A National Amenity Society

7th February 2024

Cockshotts Barn, Wesley Street, Sabden, Clitheroe, Lancashire, BB12 7QX. Pre-application consultation

Title: Proposed North and West
Elevations

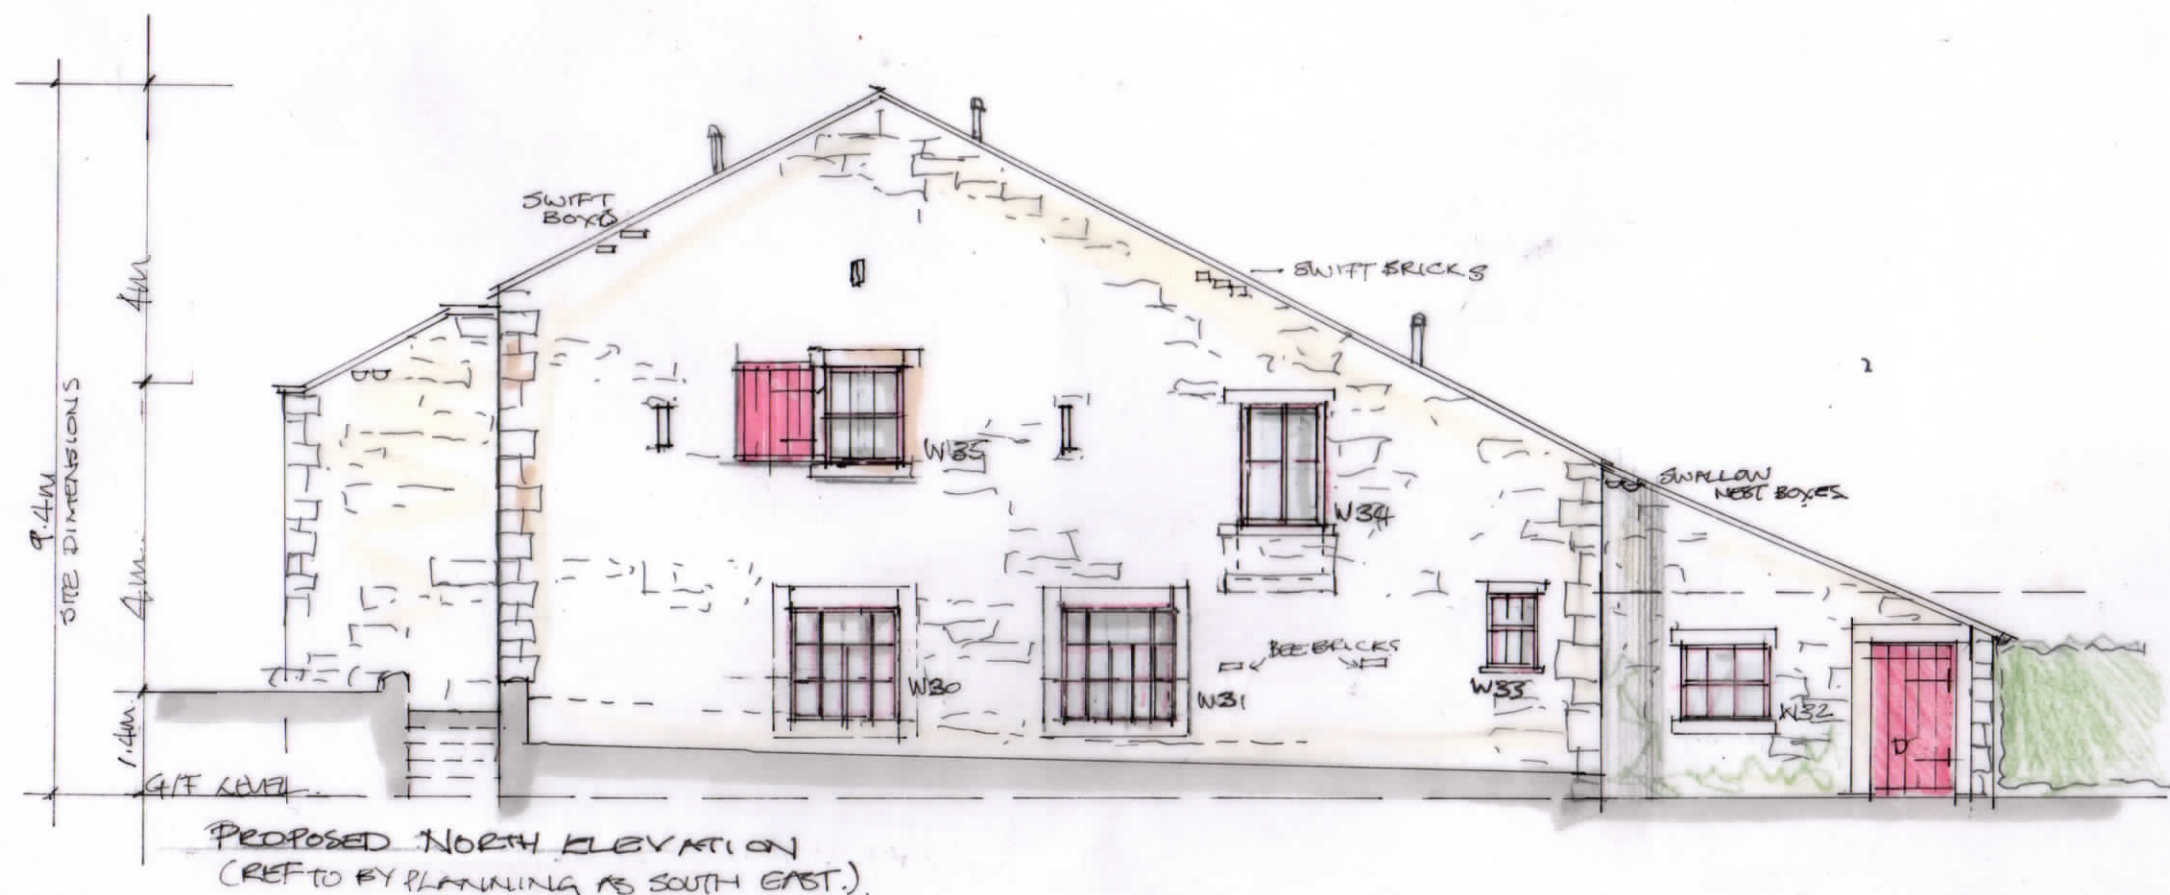
The building's significance as a barn, and the contribution this makes to the character and appearance of the Sabden Conservation Area should be conserved through minimal alterations to apertures. The ventilation slits are an important part of this. We are pleased to see they will be retained. We advise that the new window opening on the east elevation impacts the agricultural aesthetic of the building on its most prominent face. Ideally this should be omitted to better maintain the barn's agricultural character. The irregularity of openings on barns, as dictated by internal functions, are important to their character. Creating regularity in apertures makes for a very domestic appearance which should be avoided if possible. The CBA advise that the multi-paned timber casements are likely to appear overtly domestic in style. Alternatives with a more industrial style often successfully retain an agricultural aesthetic in barn conversions.

How the site is landscaped and where domestic curtilages are created requires careful consideration to manage the impact on the site's character externally. The CBA support the creation of gardens to the west (rear) of the barn. We advise that domestic influences should be minimised at the east (front) of the barn.
